**Case Officer:** Nathanael Stock

**Applicant:** Rectory Homes Ltd

**Proposal:** Discharge of Conditions 4 (architectural details), 13 (landscaping) & 15 (EV charging points) of 19/02948/F

PROJECT:			
SOUTH SIDE STEEPLE AASTON			
DRAWING:			
BUILDING STONE HEAD DETAIL			
DEPARTMENT:	DRAWN BY:	CHECKED BY:	
TECHNICAL	GL		
DRAWING No:	SCALE:	PAPER:	REV:
P.224.02.102	1:10	A3	-
STATUS:	DATE:		
PROPOSED	09.03.21

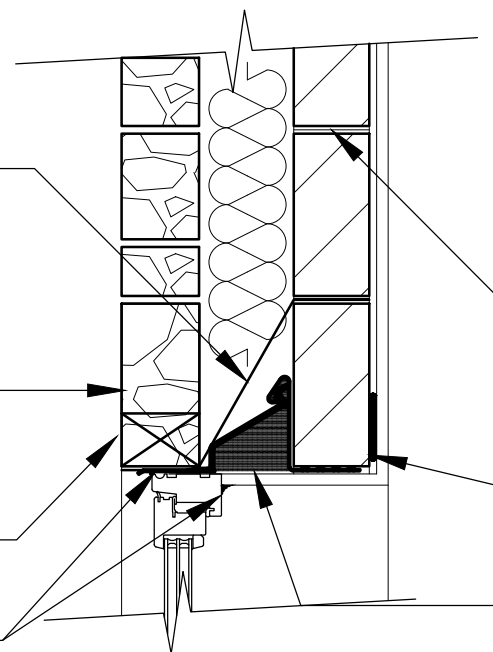
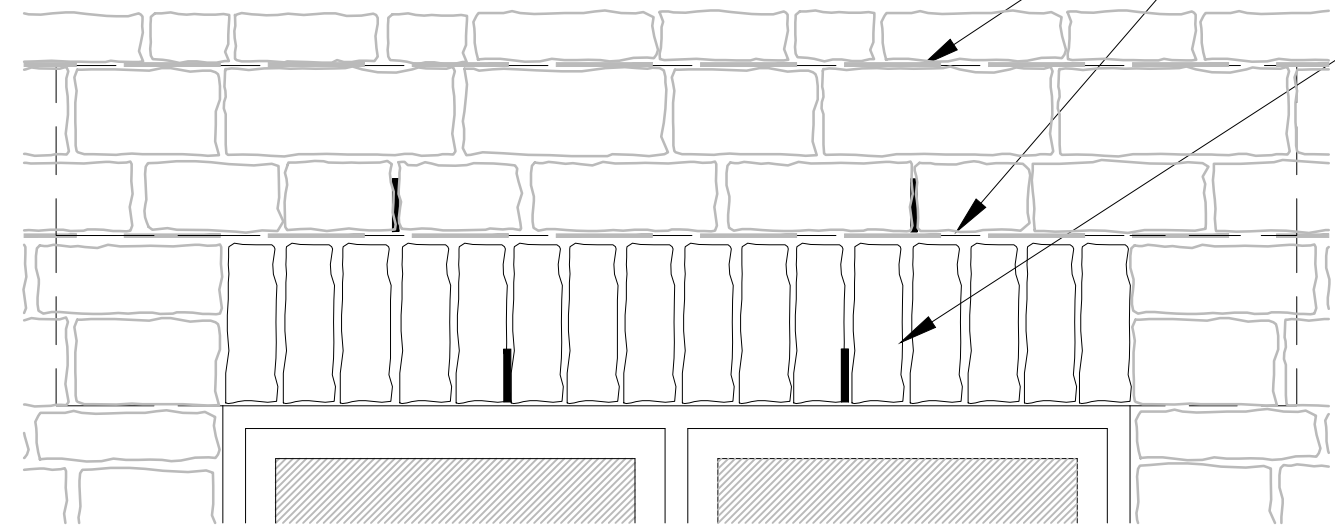
- 6.1. Condition 4 requires the submission of full details of the architectural details of the dwelling(s), including windows, doors, heads, cills, lintels, eaves and verges (at a scale of 1:20). Drawings “P.224.02.100” (stone cill detail), “P.224.02.101” (stone head detail), “P.224.02.102” (building stone head detail), “P.224.02.103” (verge detail), “P.224.02.104” (soffit detail), “P.224.02.105” (corbel detail), “P.224.02.106” (flat roof porch), “P.224.02.107” (gable roof porch on timber posts), “P.224.02.108” (flat roof porch on timber posts), along with an email to the local planning authority from Steve Kerry of Rectory Homes dated 12.10.2021 at 1608 hours in respect of fascia details, and an email to the local planning authority from Steve Kerry of Rectory Homes dated 14.09.2021 at 0918 hours in respect of soldier course headers. Subject to the said emails from Steve Kerry the submitted details are considered acceptable.

scheme: Land south of Southside,
Steeple Aston, Oxon
client: Rectory Homes
drawing: Soft Landscape
date: Apr. 2021
scale: 1:250@A1
drawing no: REC23270-11A
drawn: JNT checked: JS

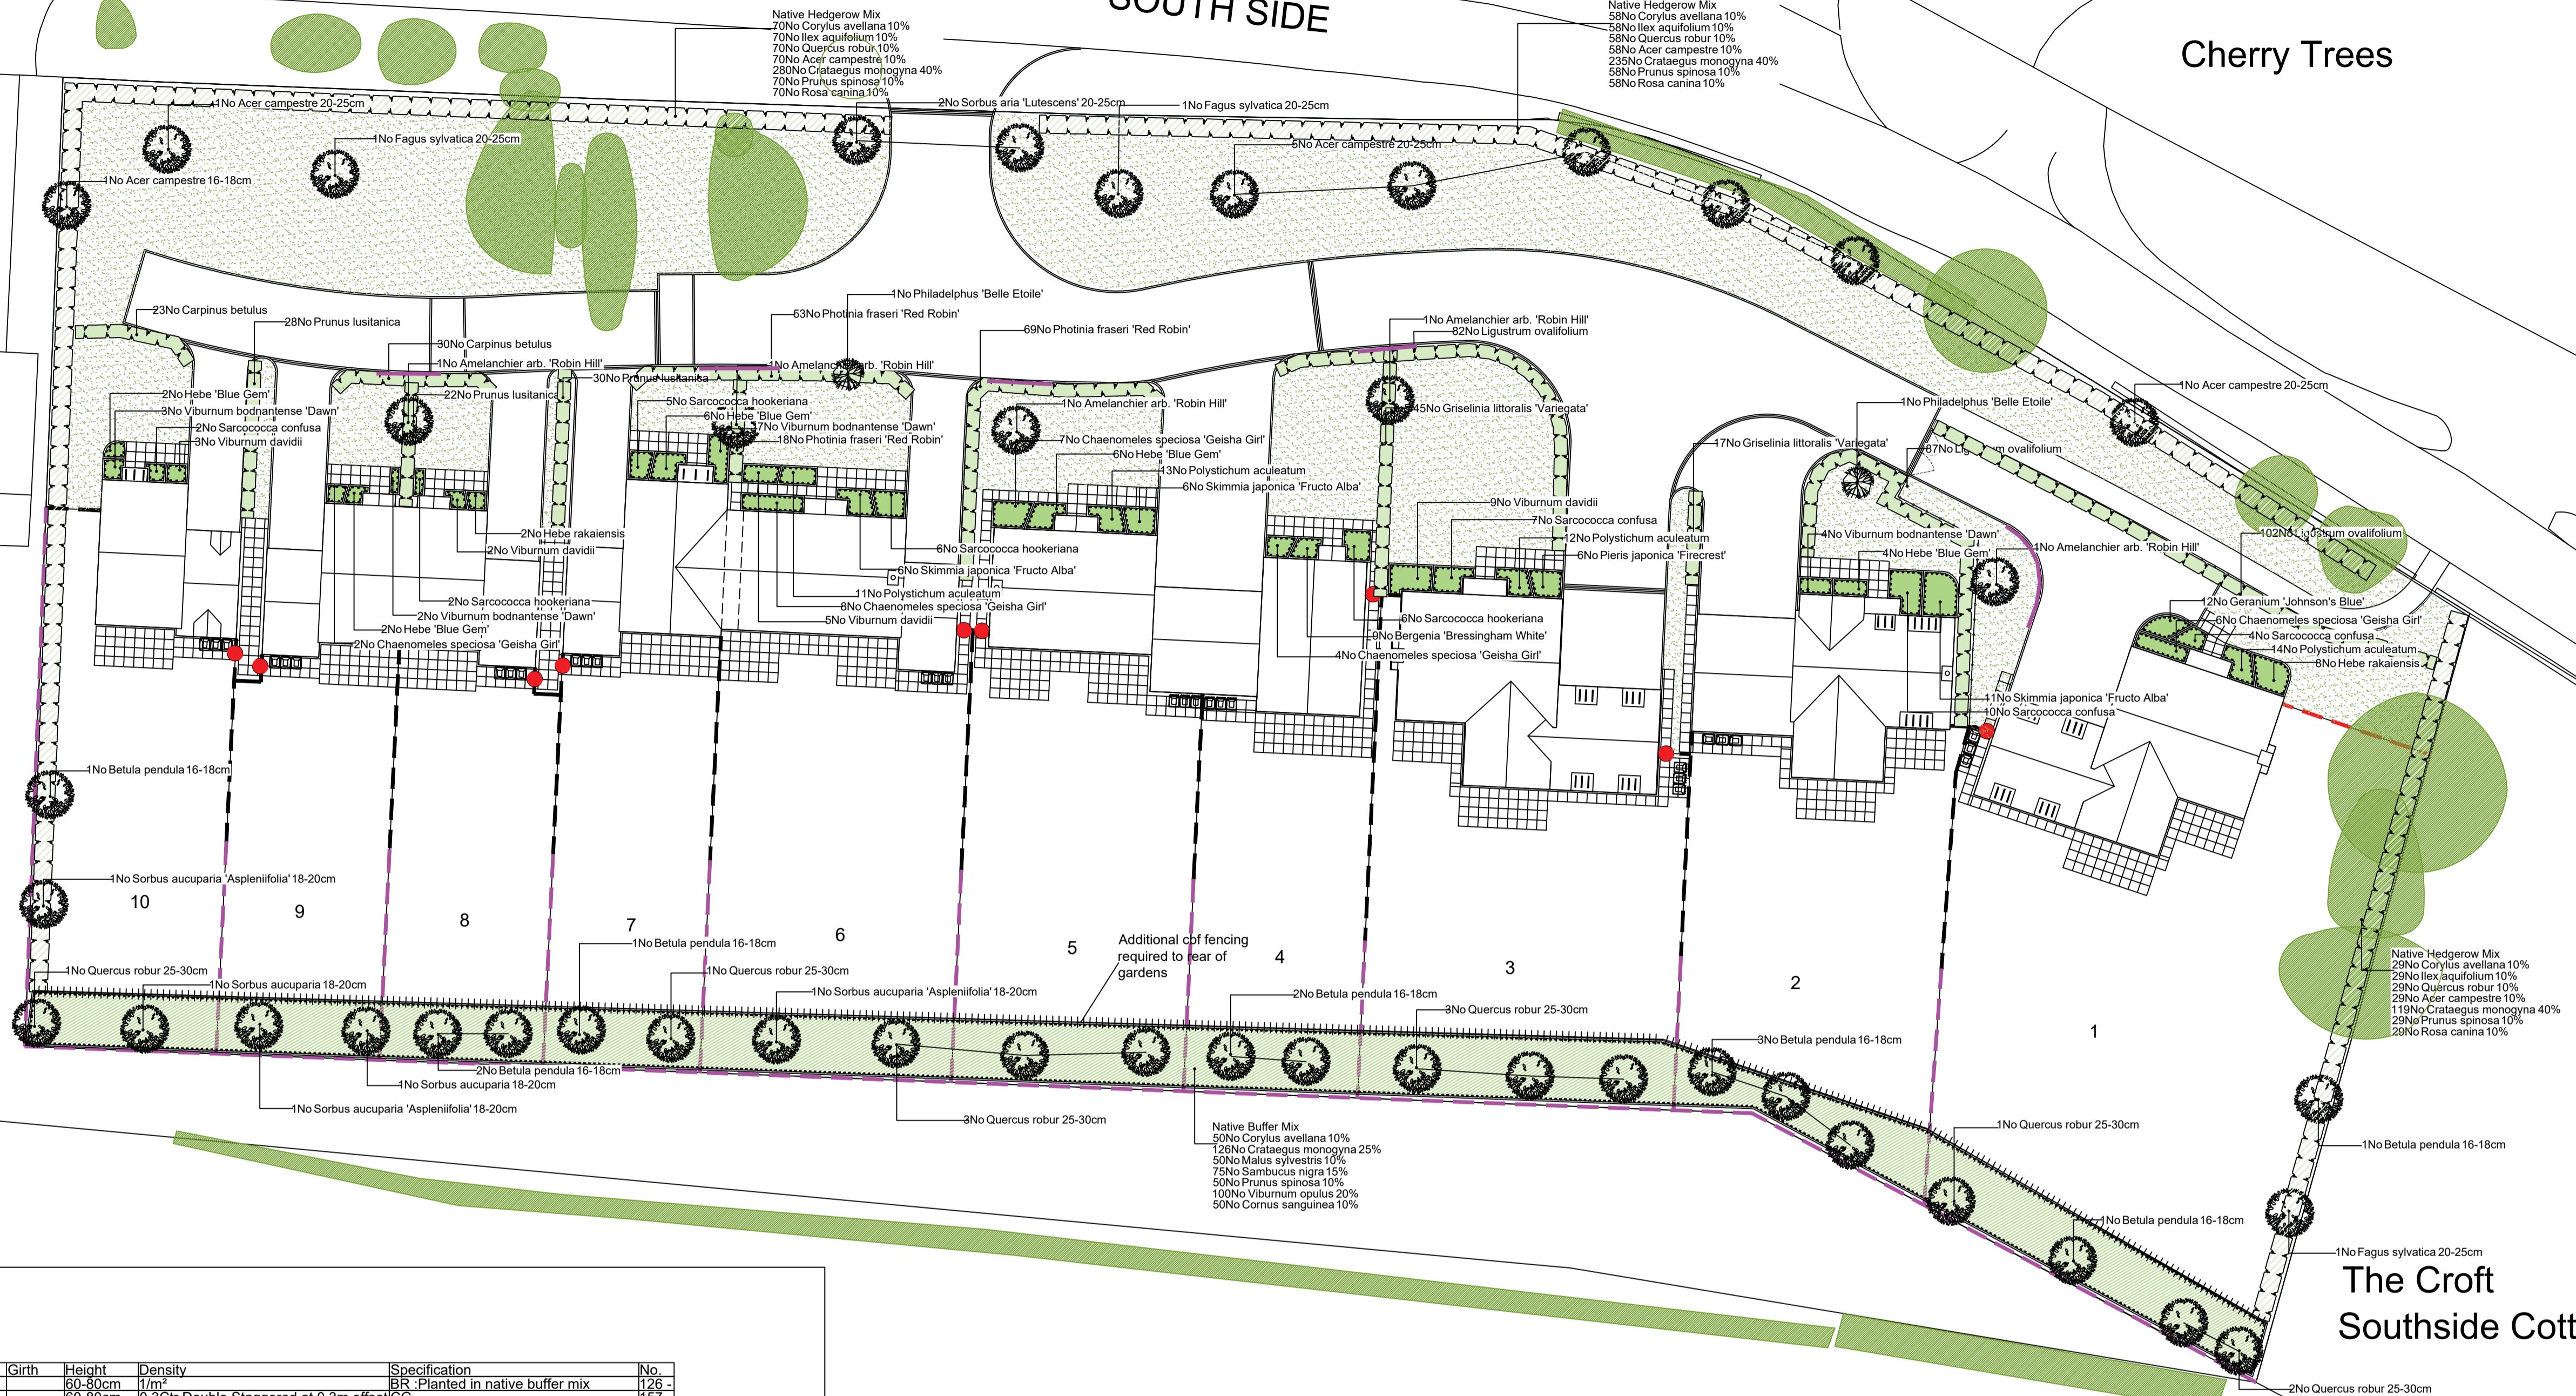
I have taken the liberty of critiquing the landscape proposals directly onto the plan – refer enclosed. I hope this is acceptable. Root barriers are to be indicated on the landscape proposals.

5.2. CDC Landscaping (30.11.21) – pleased to confirm that the Soft Landscape Proposals and the Soft Landscape Management and Maintenance Plan are now acceptable.
